Our Case Number: ABP-317121-23

Re: BusConnects Swords to City Centre Bus Corridor Scheme
Swords to Dublin City Centre

ABP case ref: 317121

BUSCONNECTS SWORDS CORE BUS CORRIDOR SCHEME

Drawing File Name	Sheet Number	Status	Rev
BCIDB-JAC-TSM_GA-0002_XX_00-DR-CR-0018	18 of 37	A	M01

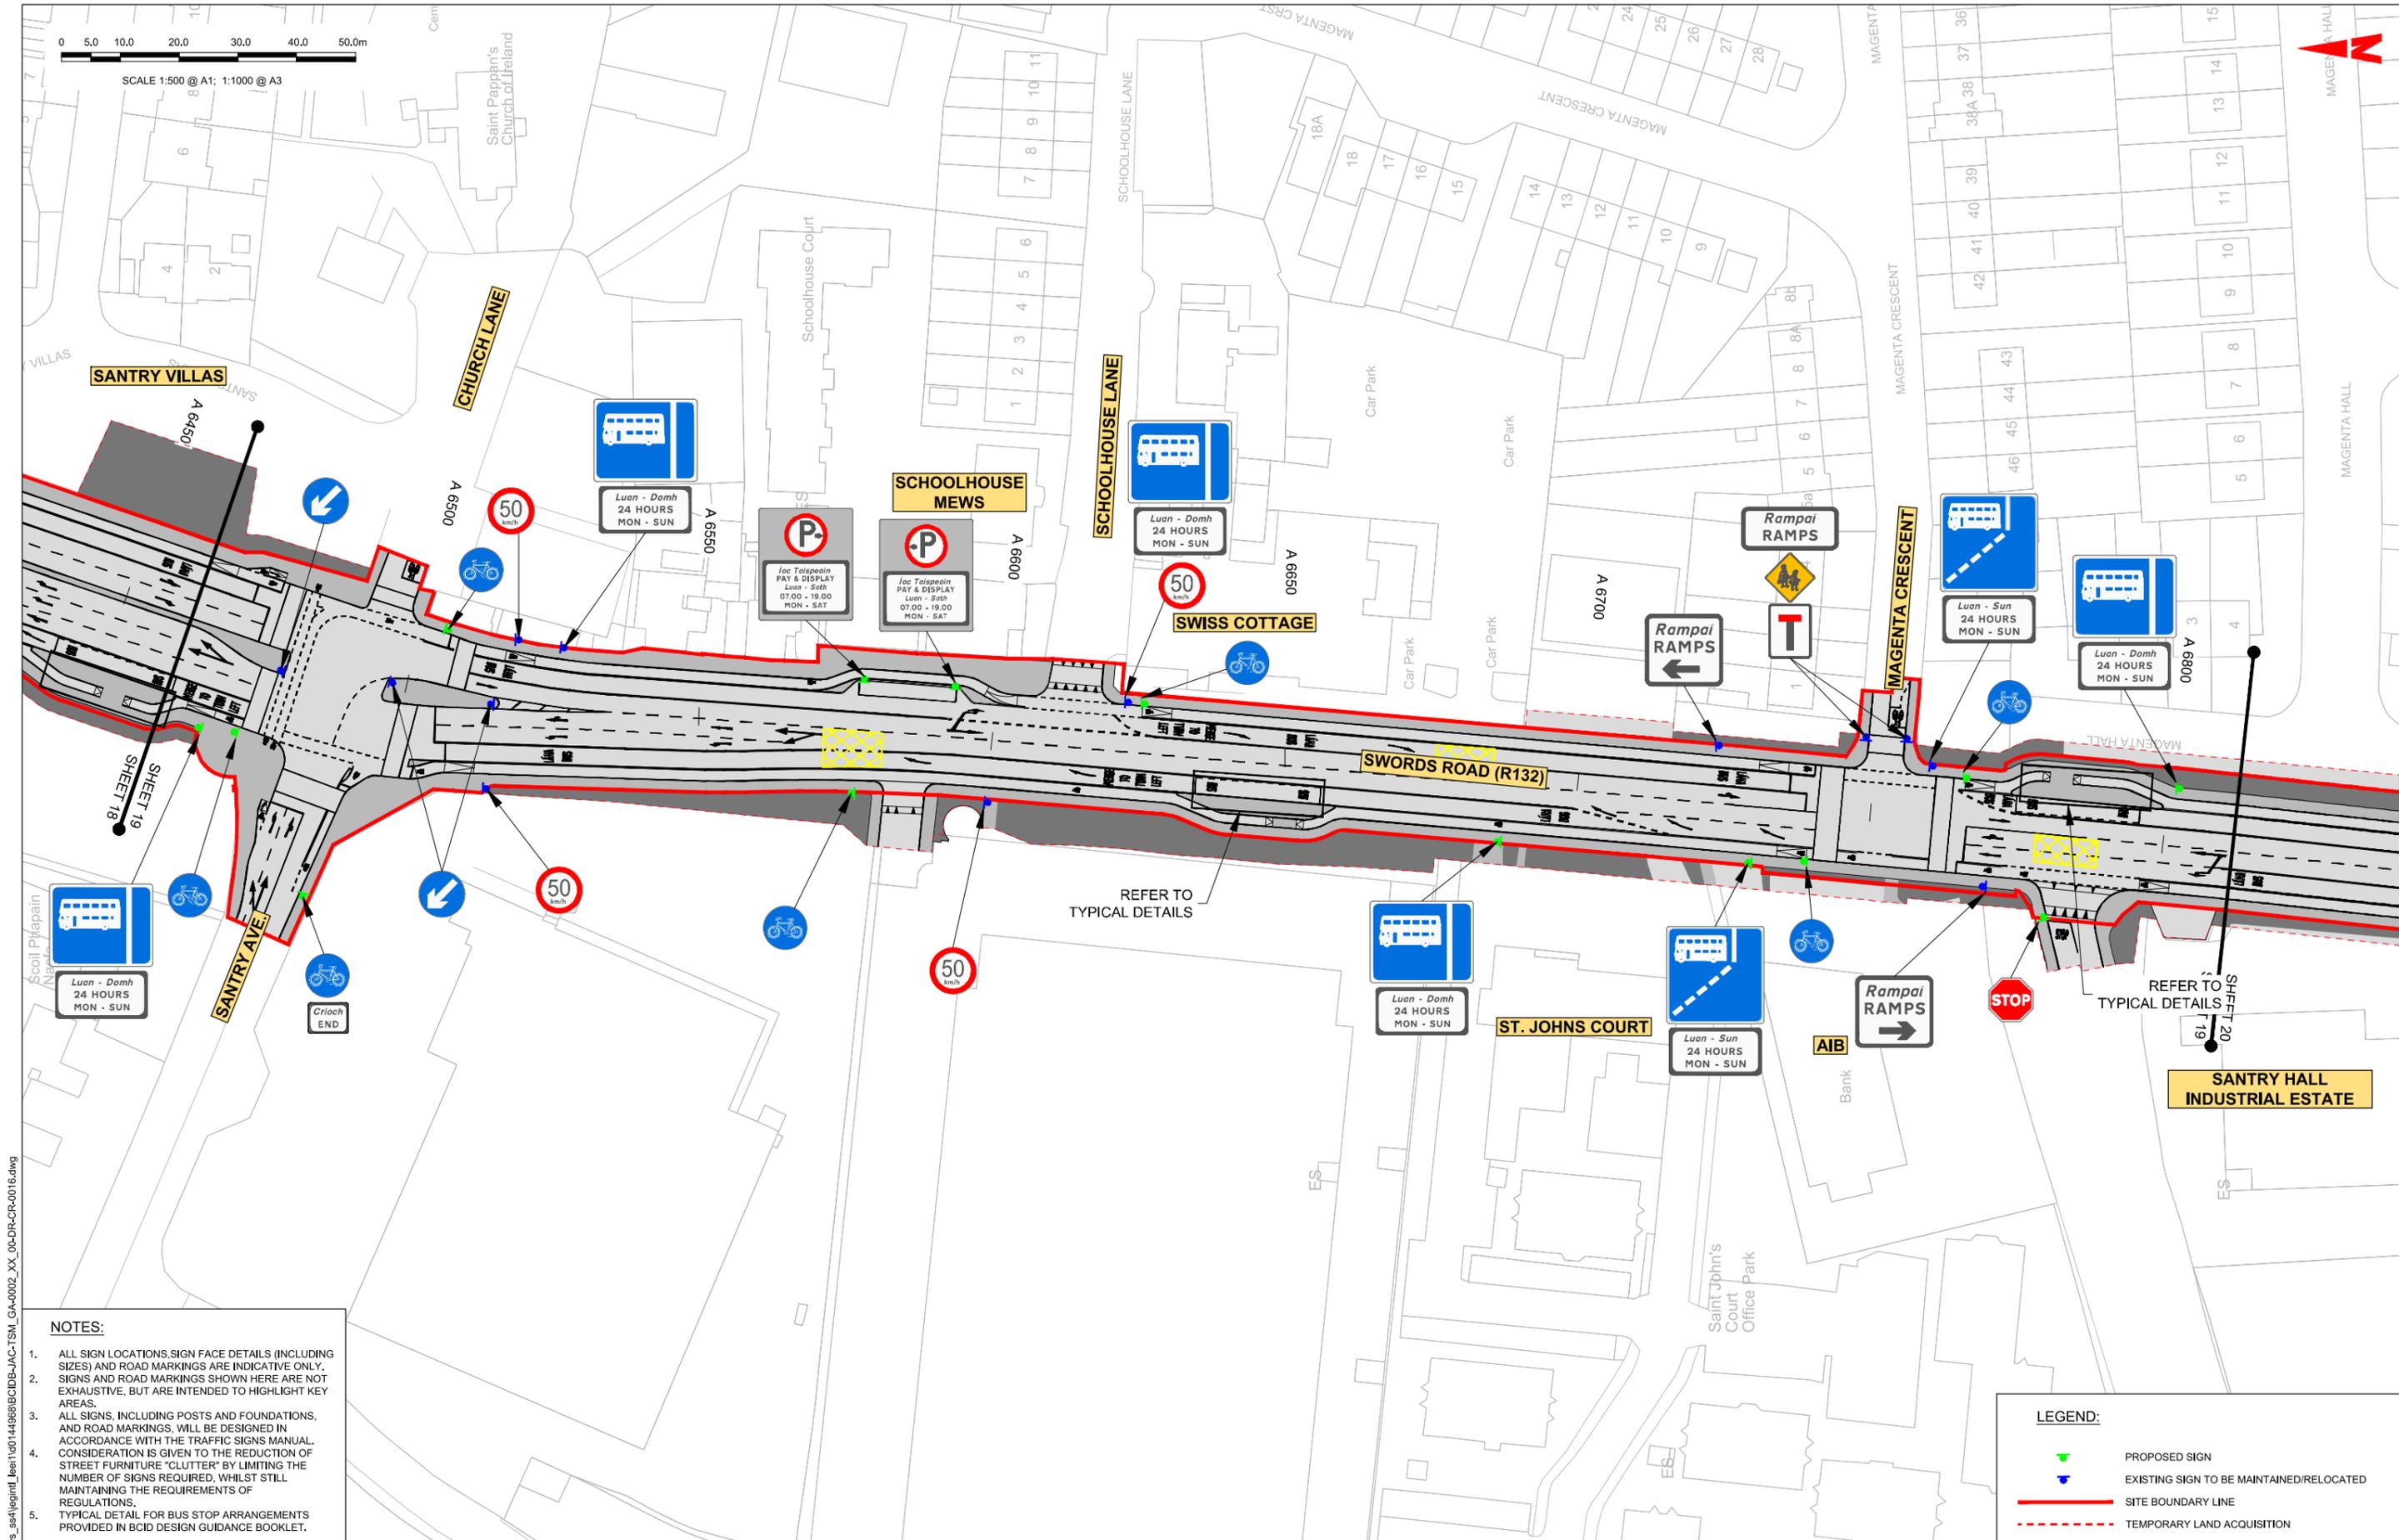
- Turnapin Lane (15)
- Coolock Lane (18)
- Santry Ave (19)
- Omni Shopping Centre (20)
- Collins Ave (25)
- Griffith Ave (28)
- Clonliffe Rd (33)
- Whitworth Rd (33)
- North Circular Rd (34)
- Gardiner St Upper (34)

Furthermore, some three and four-way junctions are missing pedestrian crossings entirely on one or more arms. These missing crossings mean a pedestrian may need to wait for three lights — or more in the case of two-stage crossings — just to cross the street and continue their journey. Section 4.4.3 Junction Design of DMURS states that “designers should provide crossings

Figure 2 Example of a junction with a missing pedestrian crossing at Coolock Lane

- Kettles Lane (sheet 5)
- Cloghran Junction (6)
- Long term parking/Kealy's Pub (9)
- Old Airport Road (12)
- Quick Park (12)
- Coolock Lane (18)
- Seven Oaks (28)
- Millmount Ave (31)
- Botanic Avenue (31)
- Clonliffe Rd (33)
- Whitworth Rd (33)
- Belvedere Road (34)

Drawing File Name: BCIDB-JAC-TSM_GA-0002_XX_00-DR-CR-0036
Sheet Number: 36 of 37
Status: A
Rev: M01

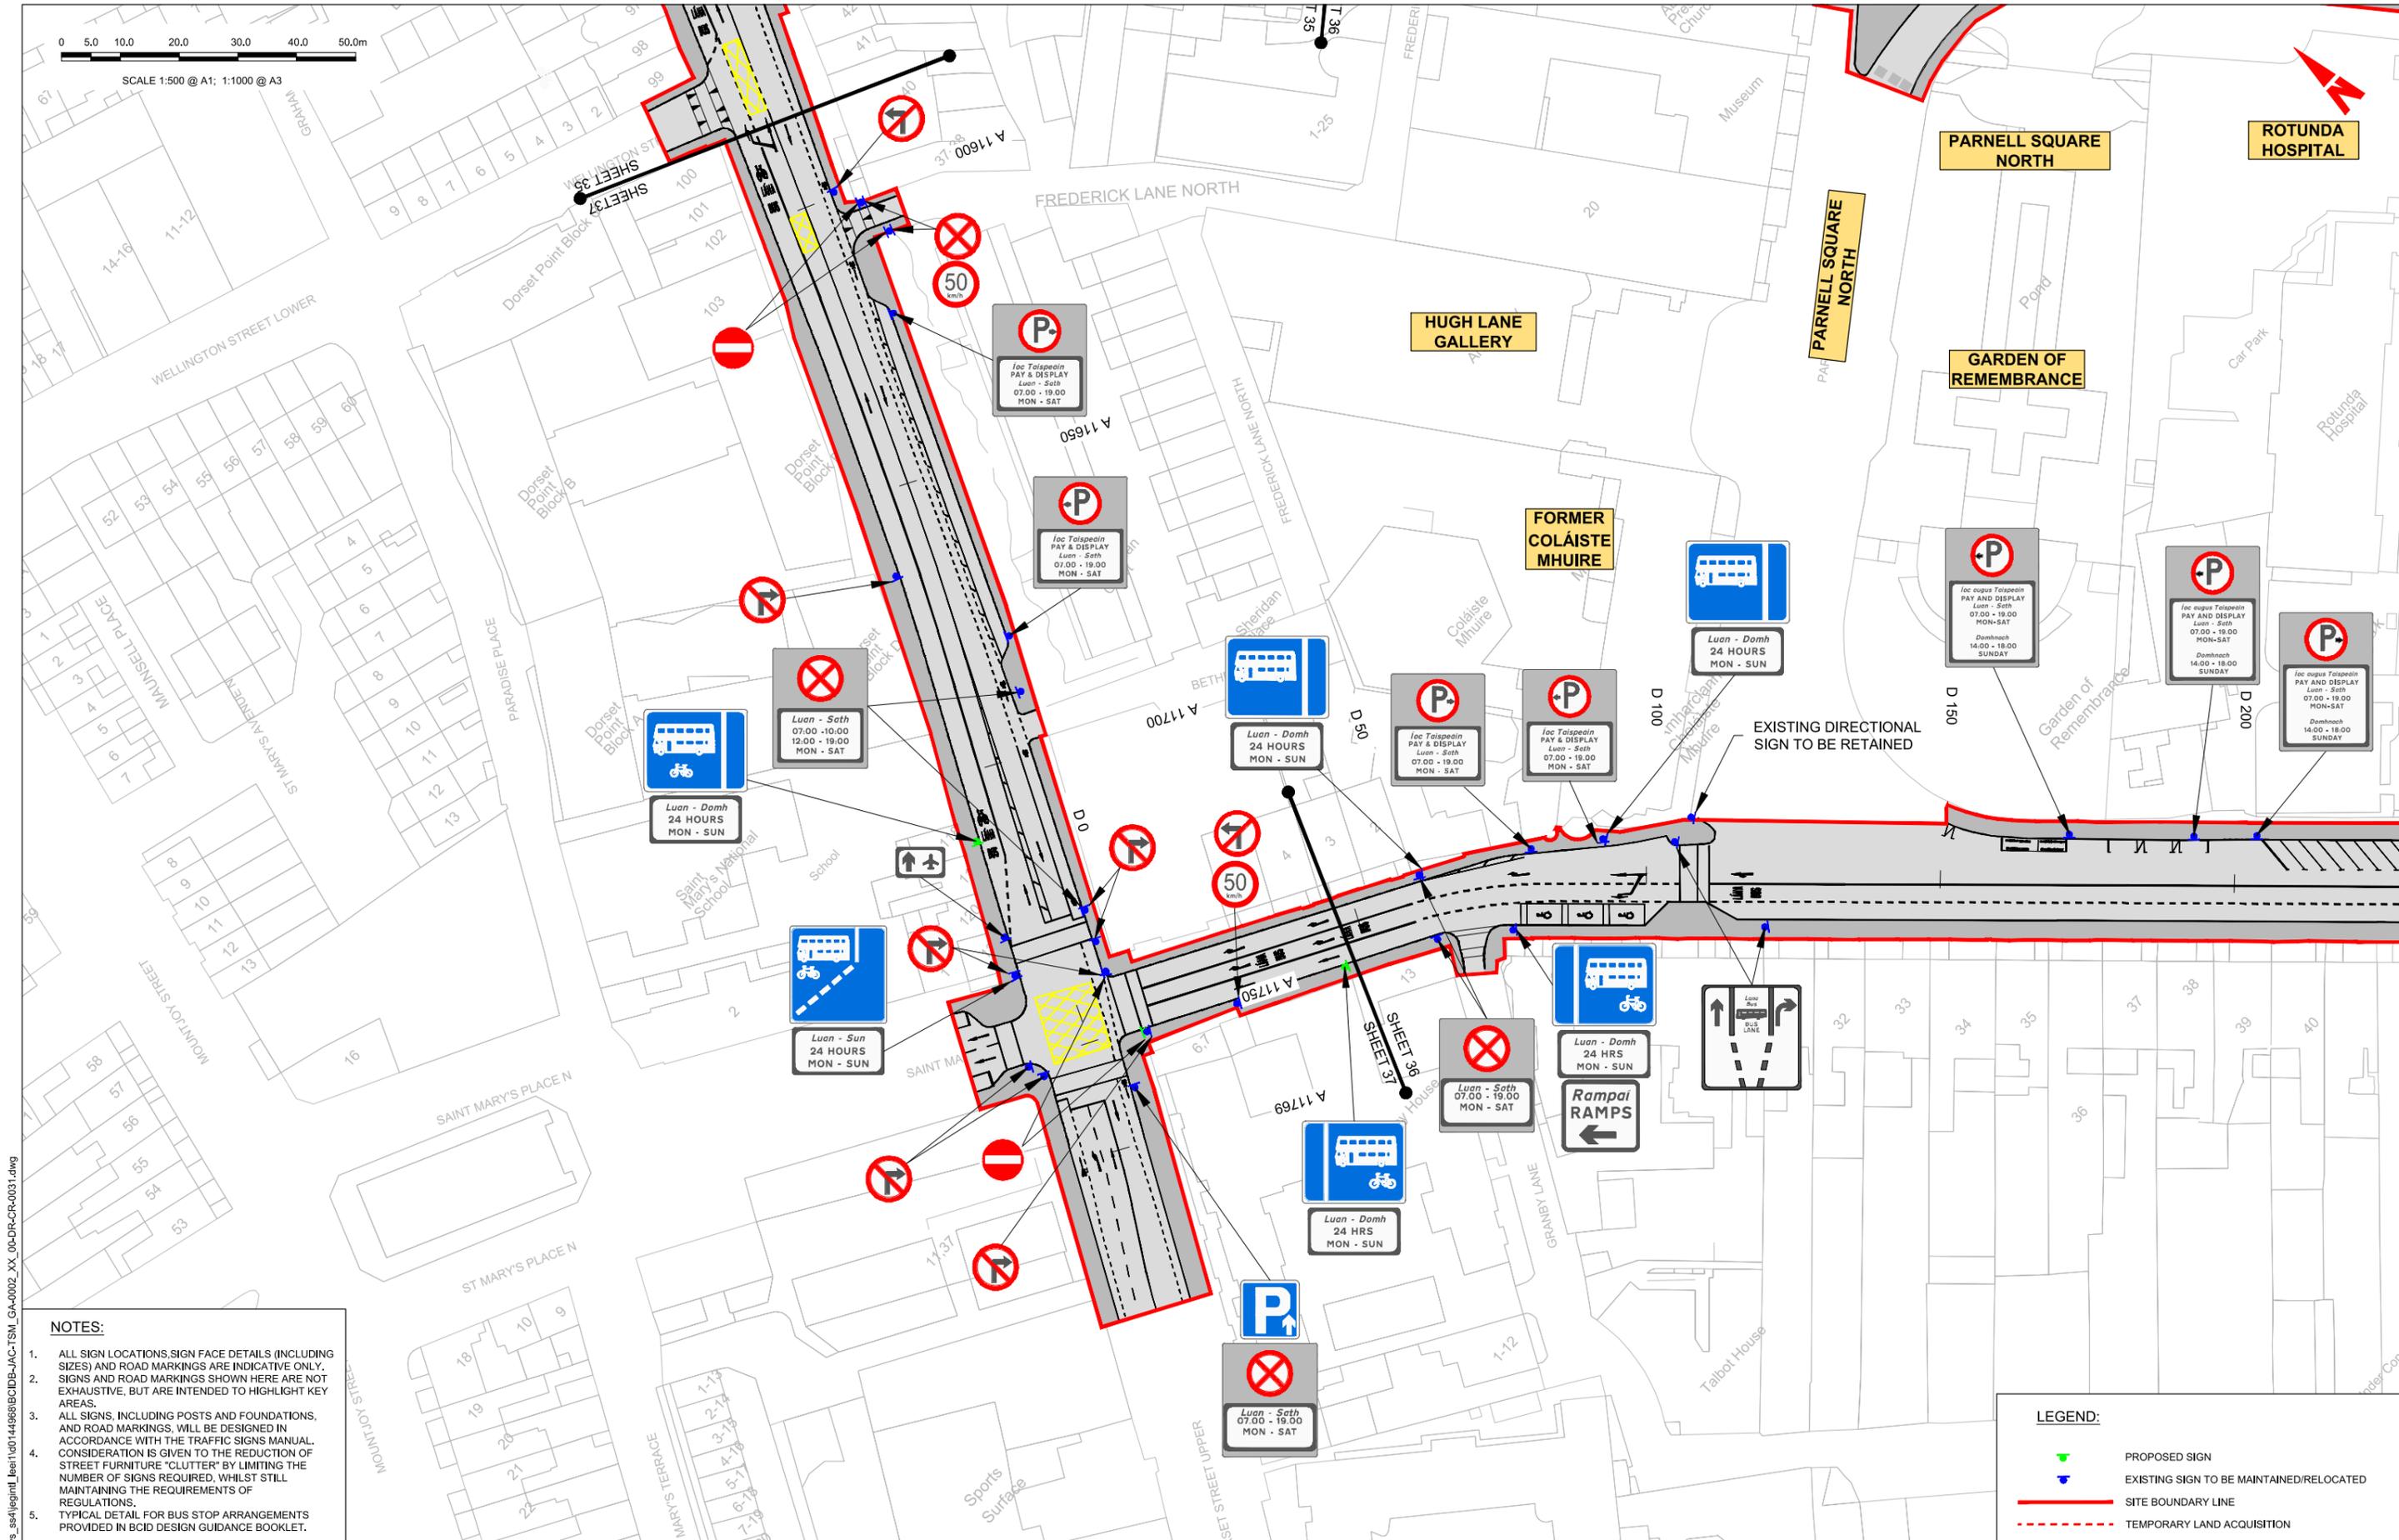
- North Circular Rd (34)
- Gardiner St. Upper (34)
- Parnell Sq W (36)
